CITY OF PORTLAND, MAINE  
Department of Building Inspection

# Certificate of Occupancy

LOCATION 46 Roaringbrook Rd (Lot #49) 397-A-001

**RE:** Temporary Certificate of Occupancy for 46 Roaring Brook

<b>SITE PLAN</b> OF <b>LOT 49 - PINELoch WOODS</b> PORTLAND, MAINE FOR <b>TIMOTHY HIGGINS</b>		
<b>Owen Haskell, Inc.</b> <i>Civil Engineers</i> <i>Land Surveyors</i> South Portland, Maine		
Drwn By	EC	Job No.
Trace By	EC	JULY 29, 1994
Check By	LSS	8523P
Bk No	673	Scale
		1" = 30'
		Drwg. No.
		1

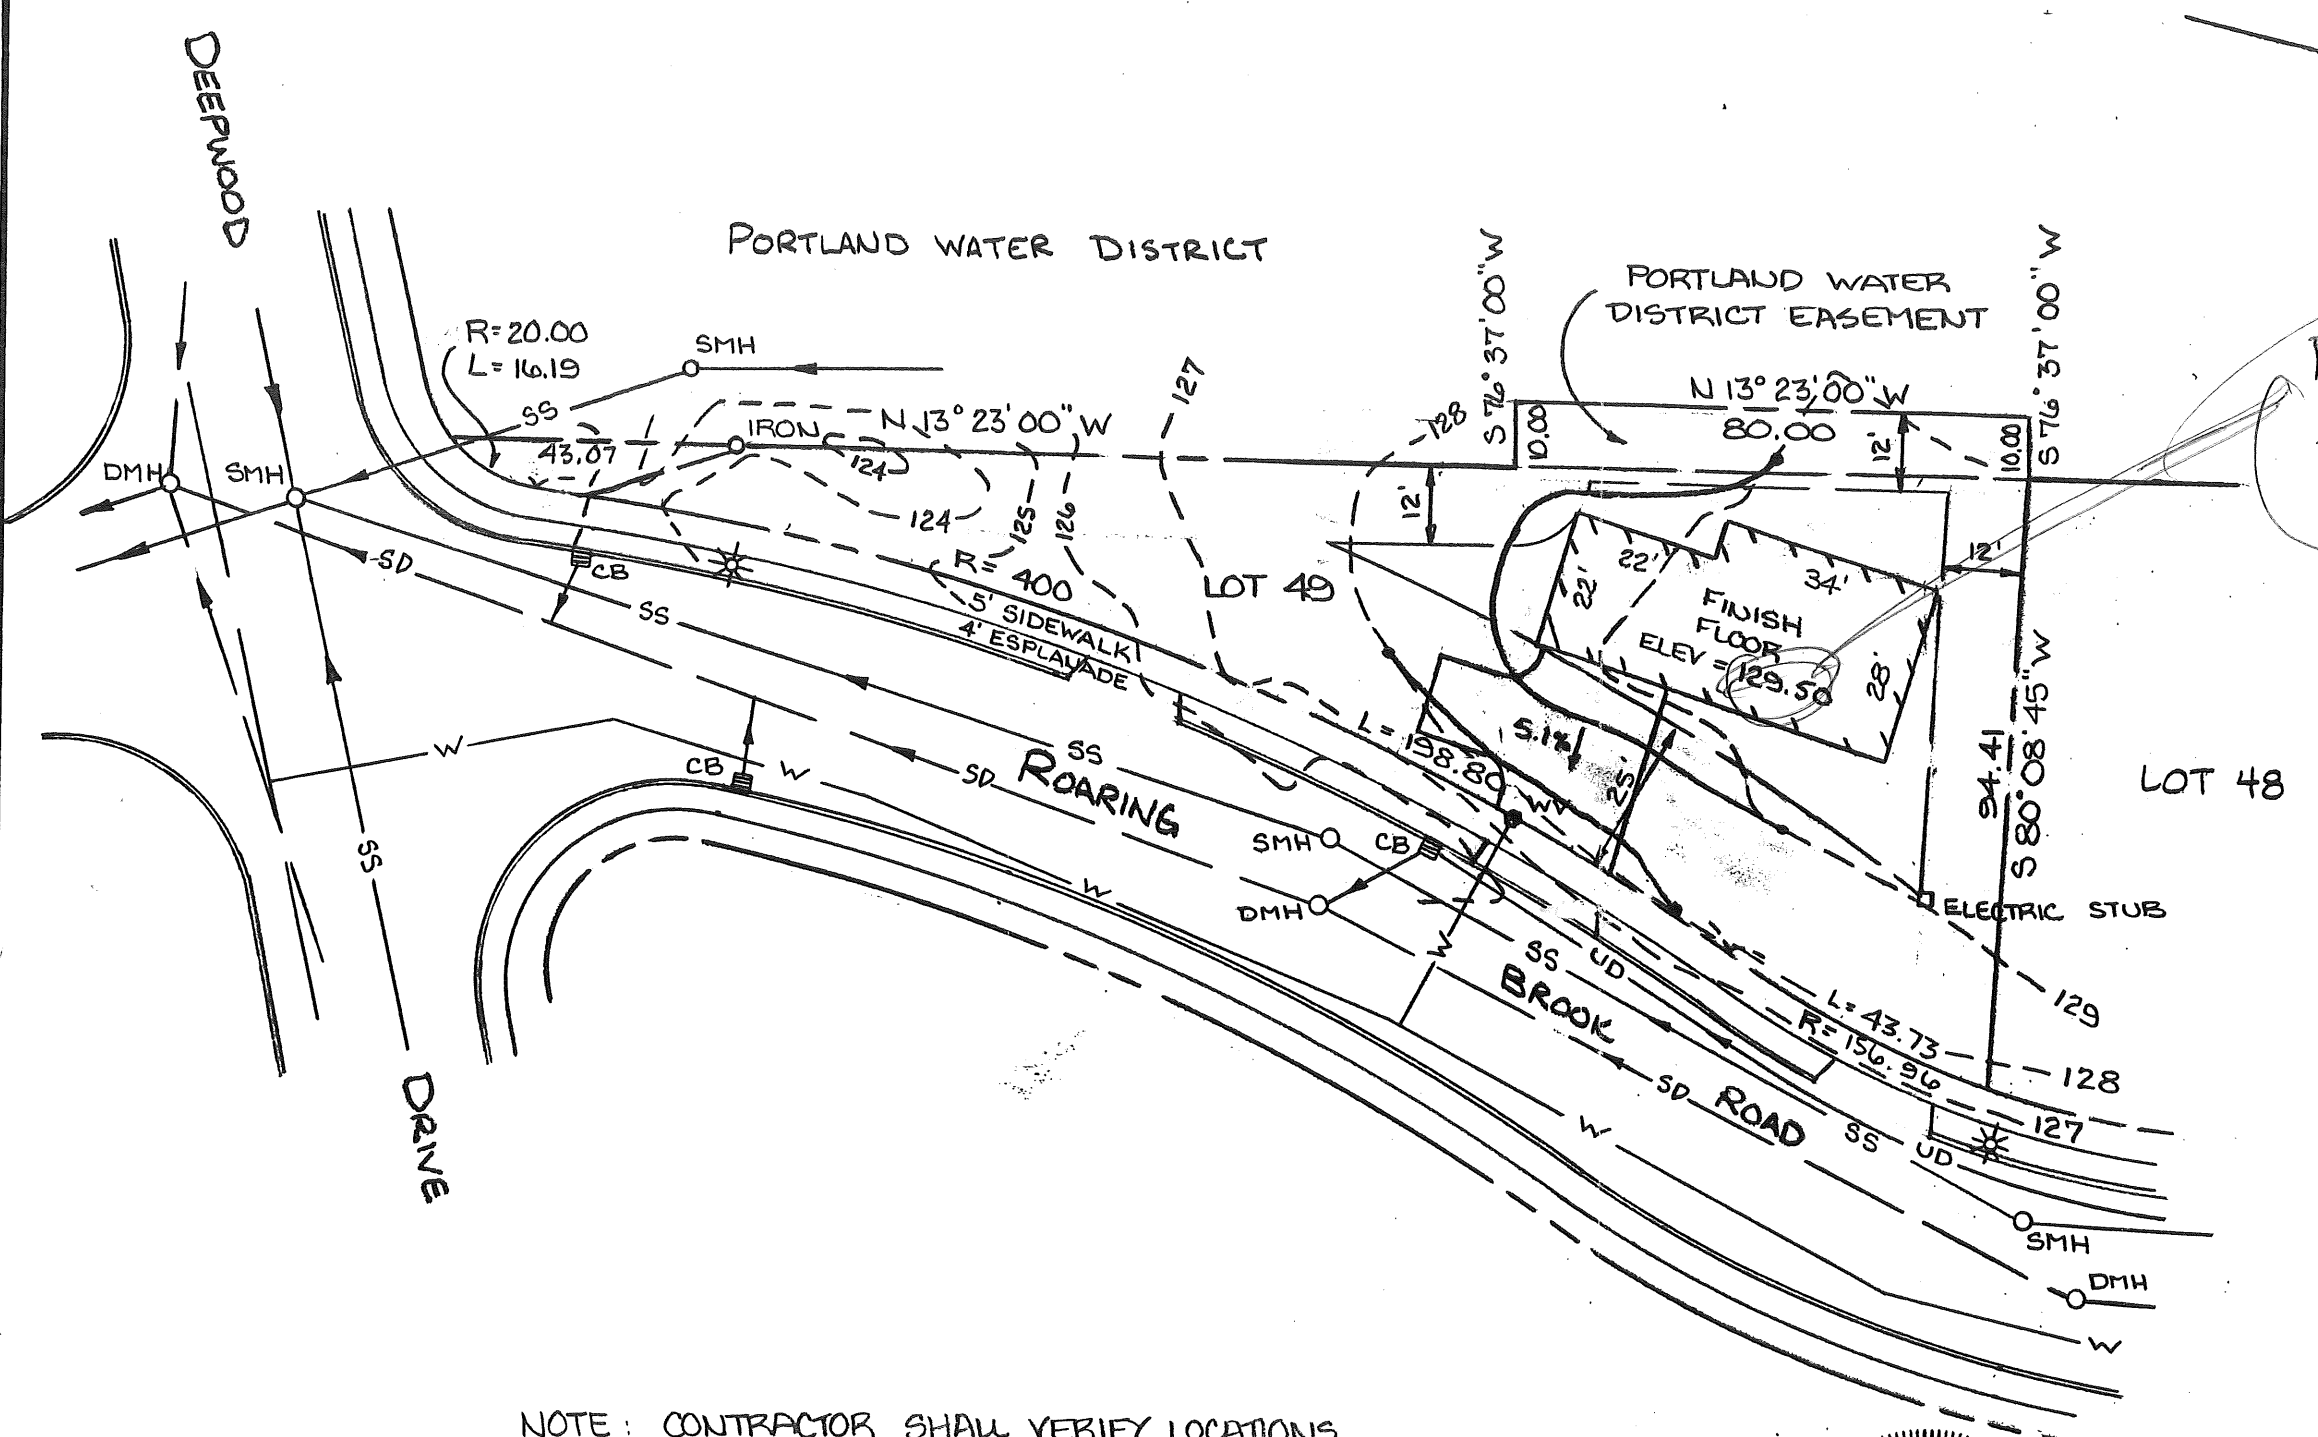
1. At the time of my inspection, the ground surface was covered with 1-2" of snow making it difficult to review the lot grading. It appears that lot grading may be necessary in the spring. There is an open hole/trench on the northern front corner of the house. This open trench should be filled and graded to conform to the natural grade and provide positive drainage away from the house.
2. The disturbed lot area shall be loamed, seeded and mulched no later than May 14, 1996 and approved by the Development Review Coordinator.
